March 13, 2017

Re: Restaurant and Mercantile Fit-Up, 6 City Center

Portland, Maine

Please see the answers below and attachments to address your comments.

4 SECTION THROUGH OPEN SHELVES
 1/2" = 1'-0"

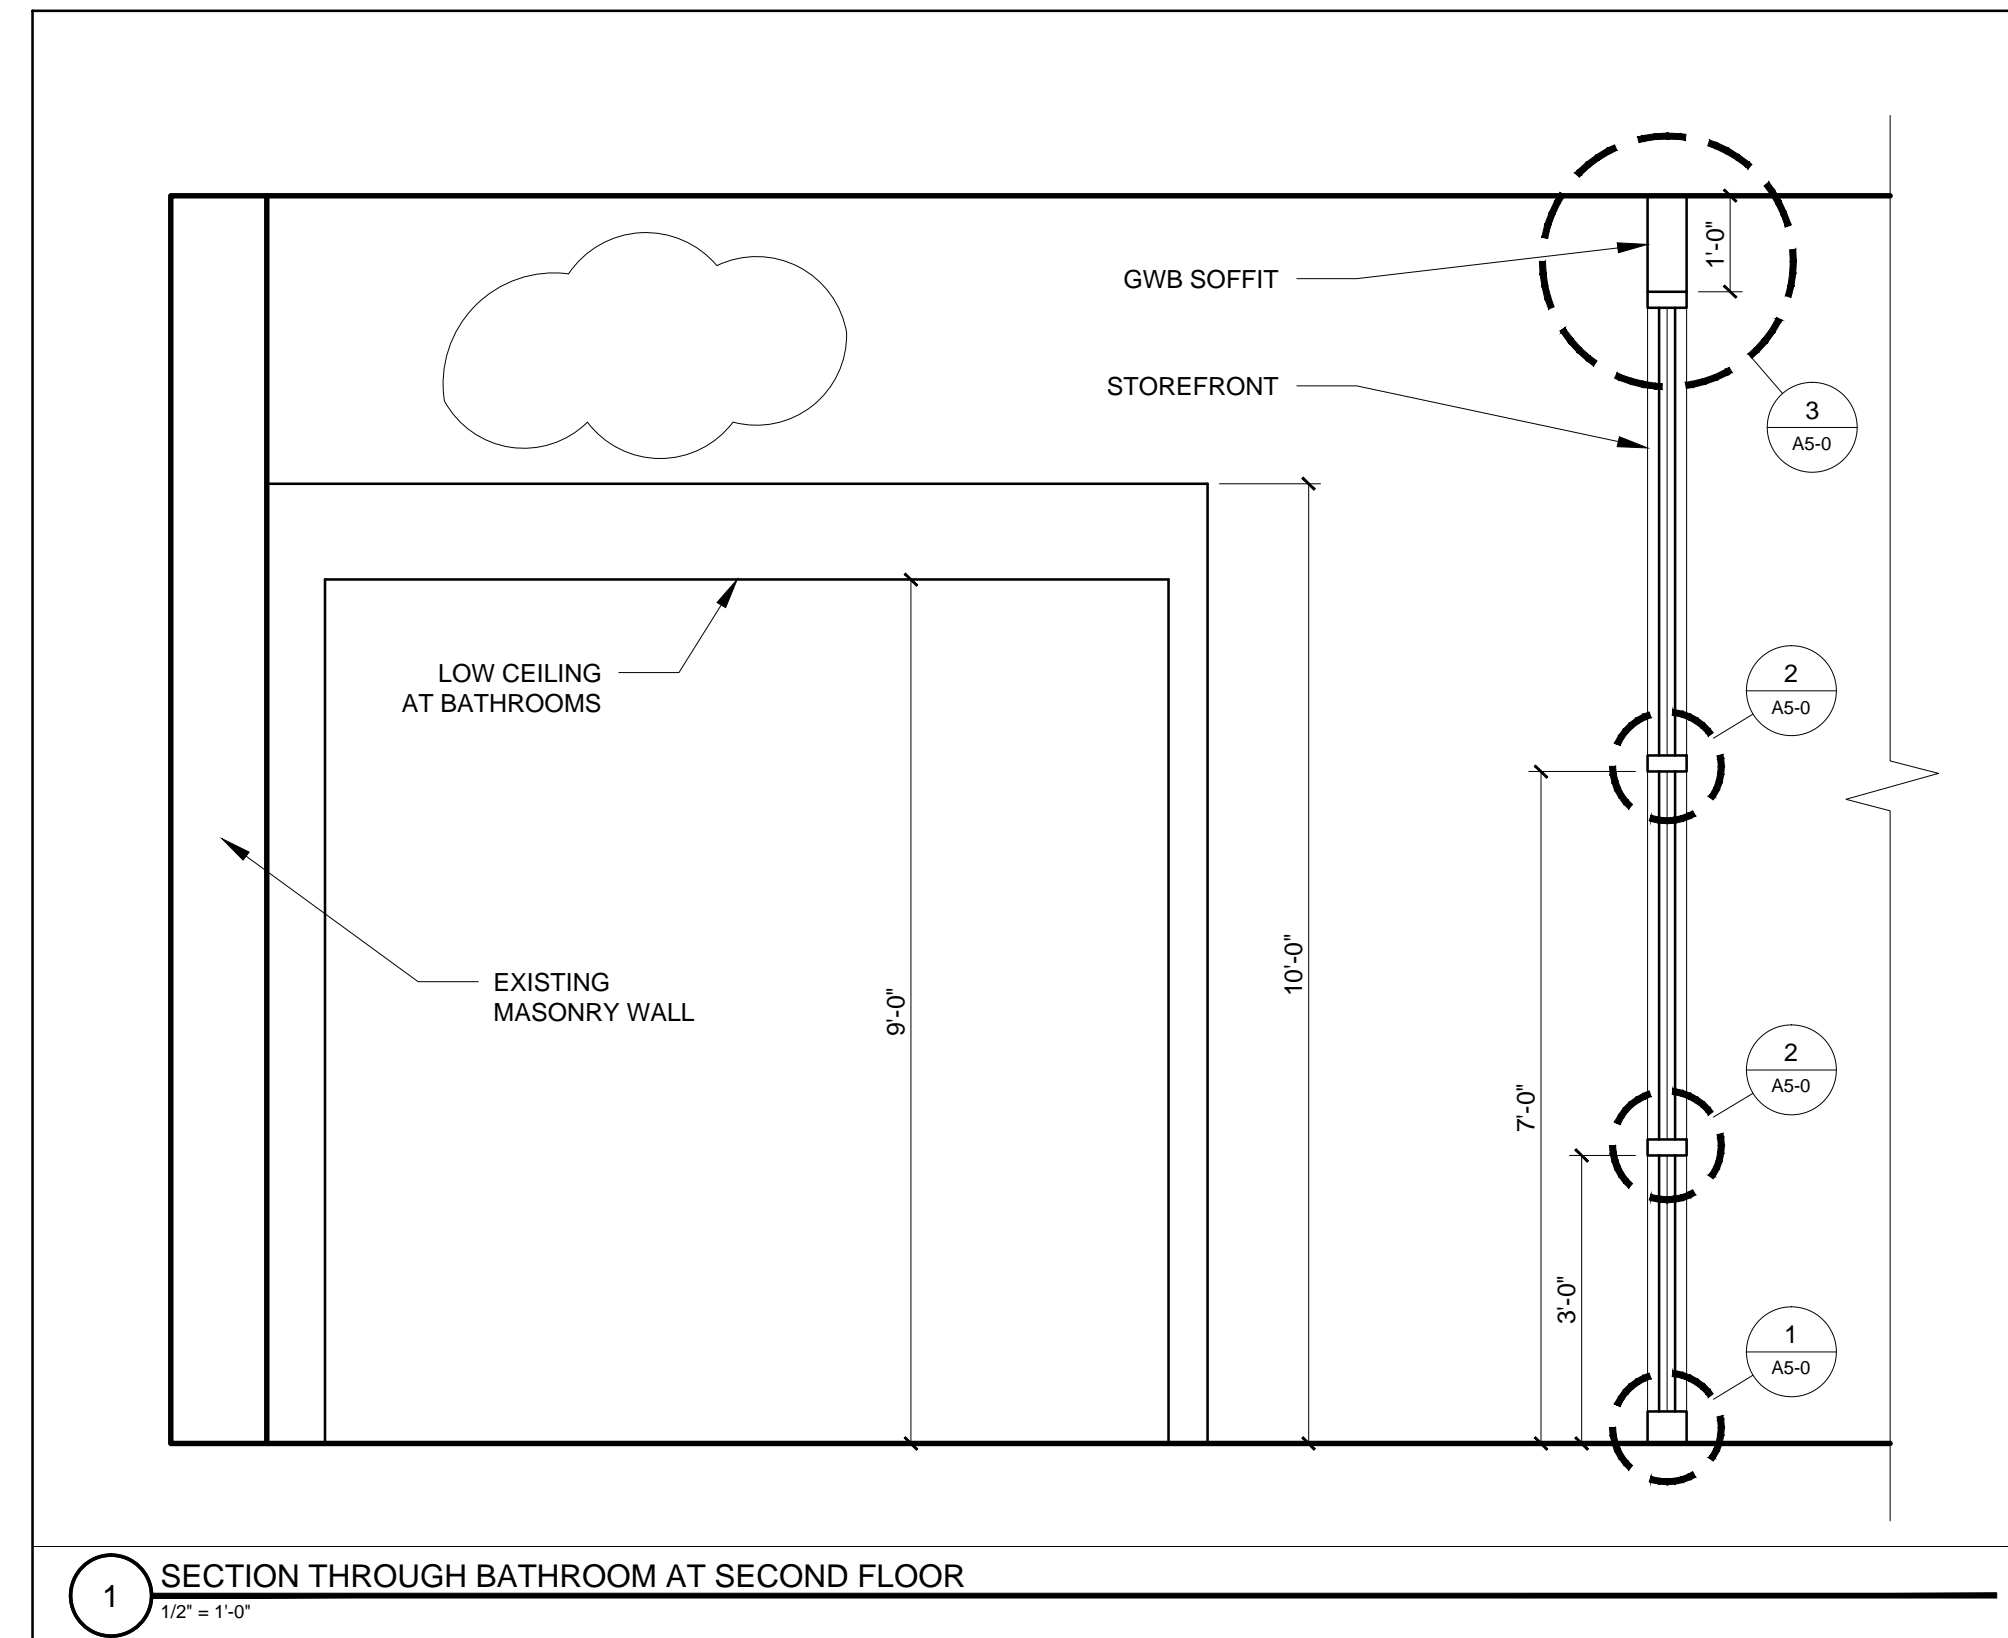
A3-0 There will not be any equipment or storage on top of the bathroom ceiling
